Planning Department
Alan Varela, Director

July 19, 2022

**Re: UNMH Crisis Triage Center – 2600 Marble Ave. NE
ESC Plan Engineers Stamp Date: 7/5/2022 – (J16E019)**

EROSION CONTROL PLAN - UNMH CRISIS TRIAGE CENTER

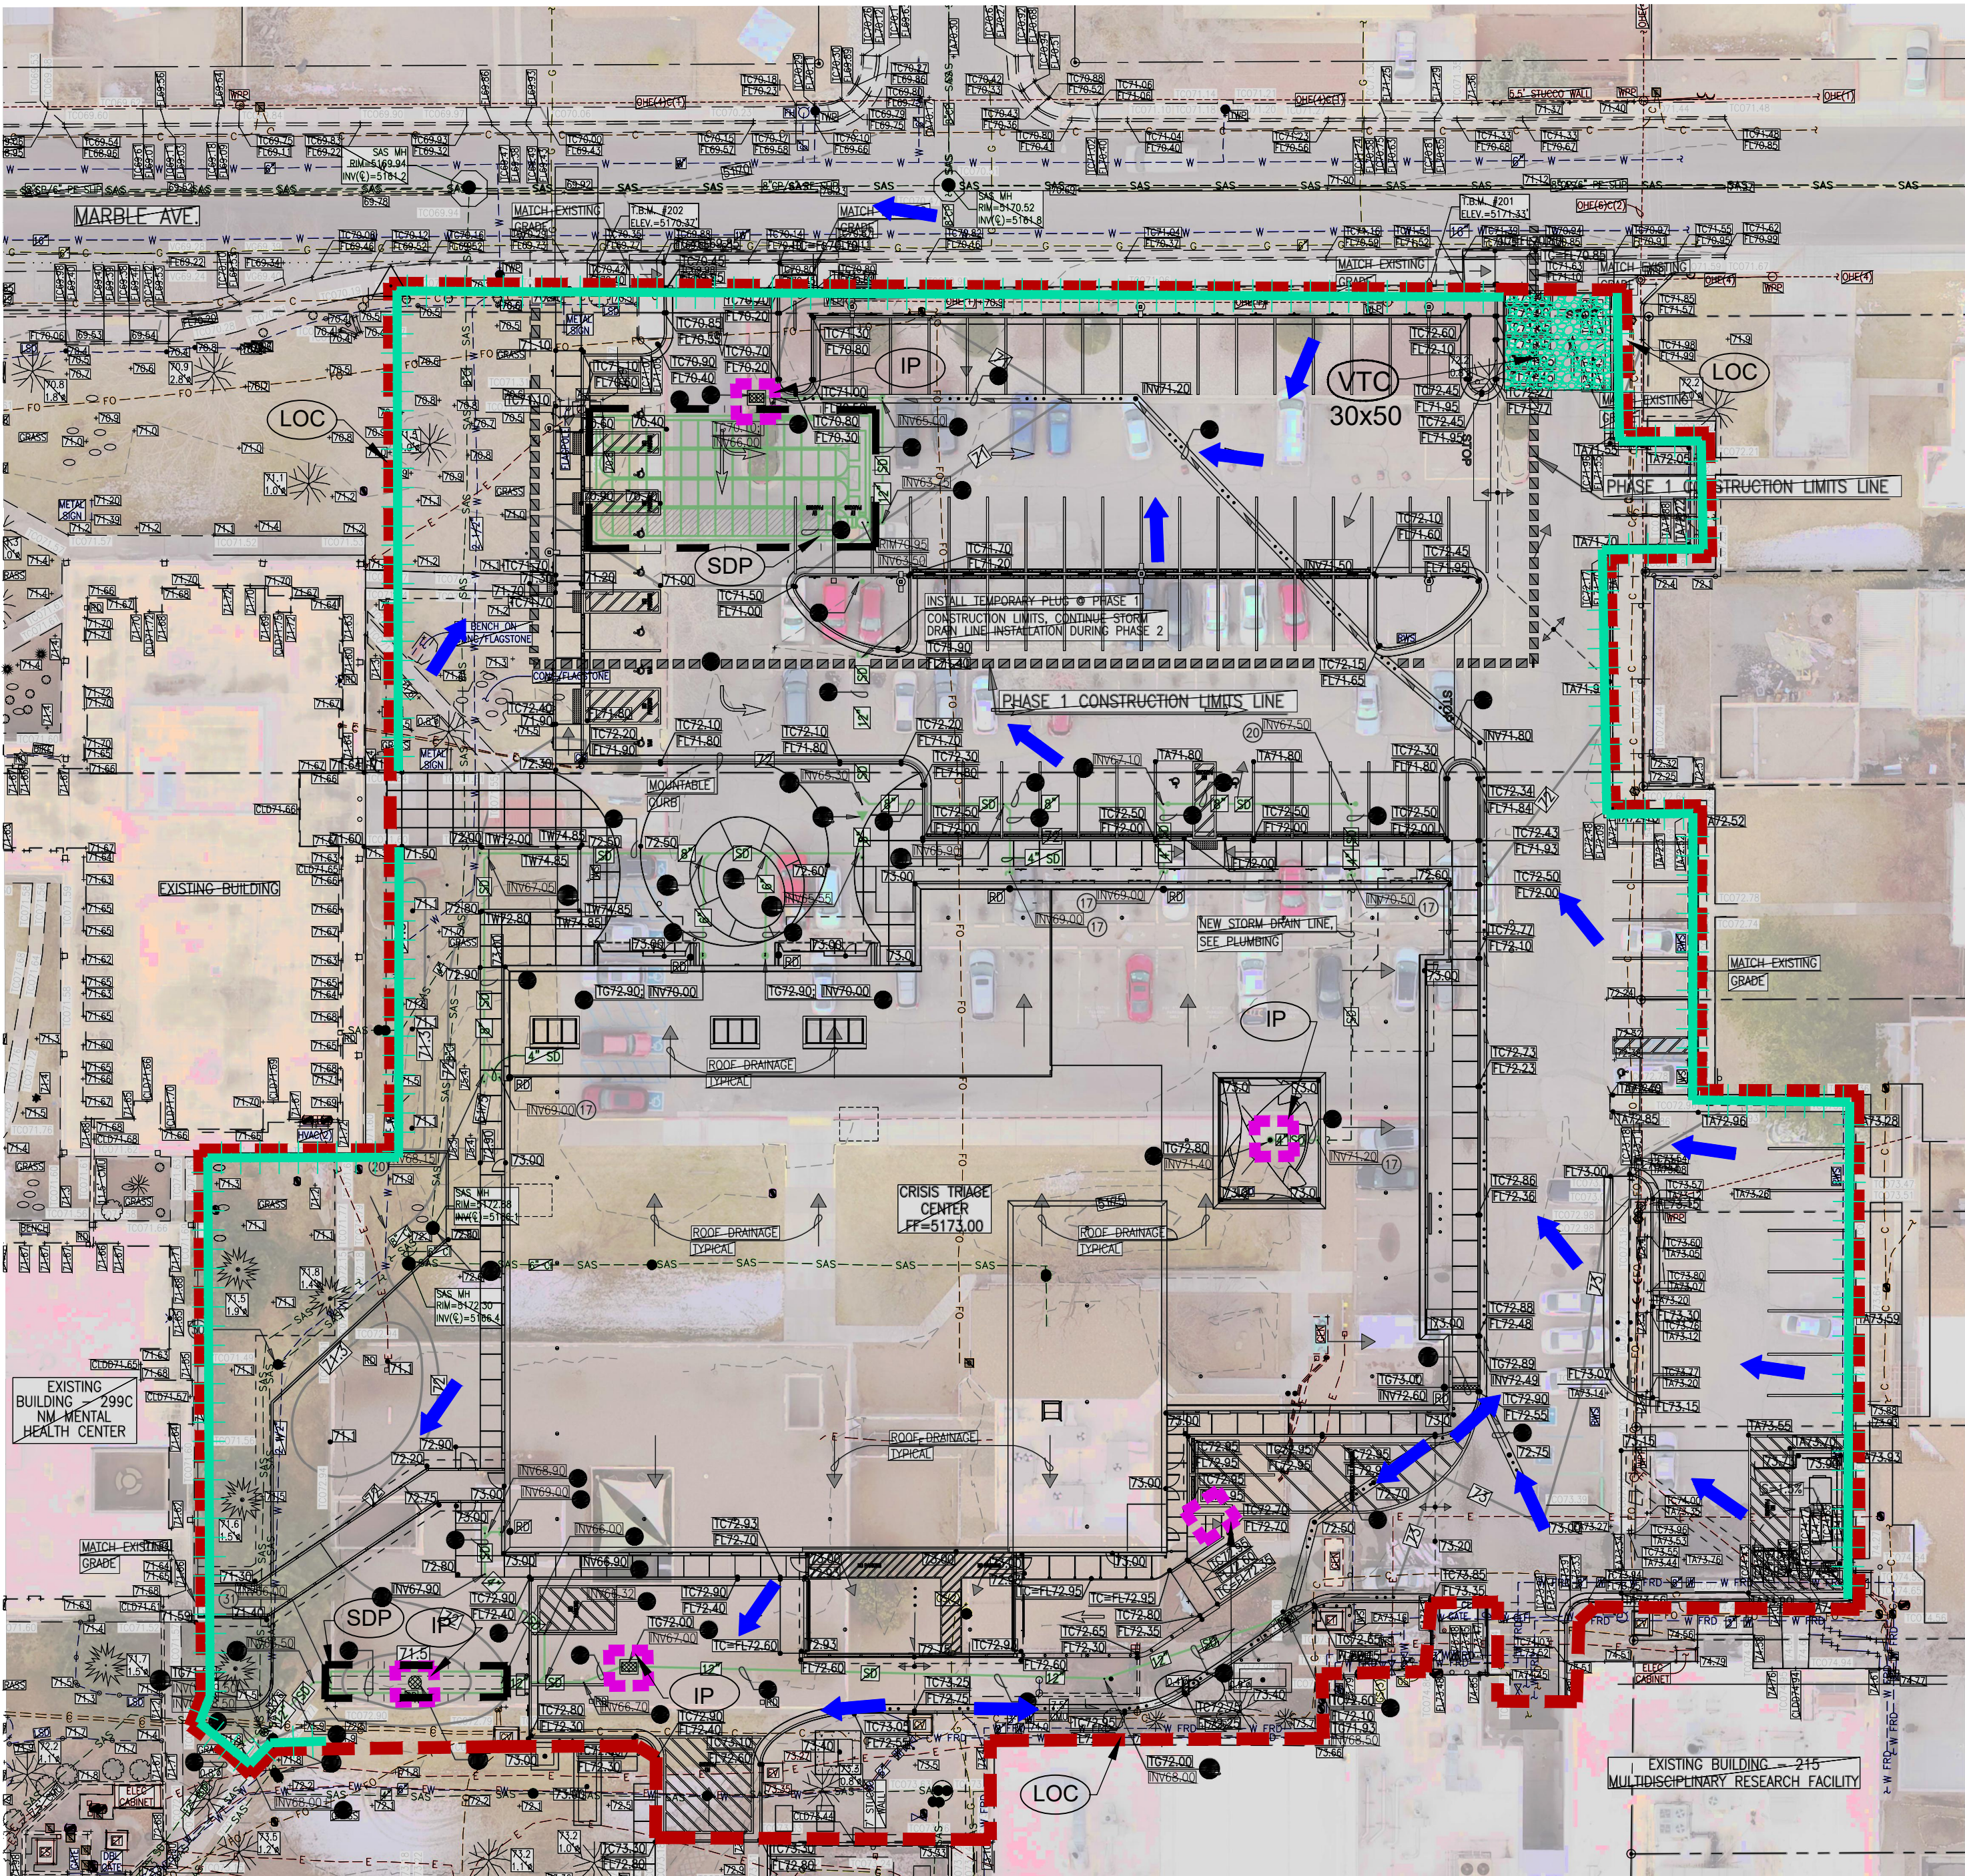
1. The ESC Plan can't be approved until after Hydrology approves the G&D Plan. The existing and proposed grades must be shown on the ESC Plan, and they must agree with the Grading Plan approved by Hydrology (CGP7.2.4.b.ii).

3. The Information Sheet must include accurate Property Owner contact information. The accurate name and contact information for the entity in control of the property rights is required and should also be shown on the plan.

4. Update the engineer's stamp date each time the plan is changed.
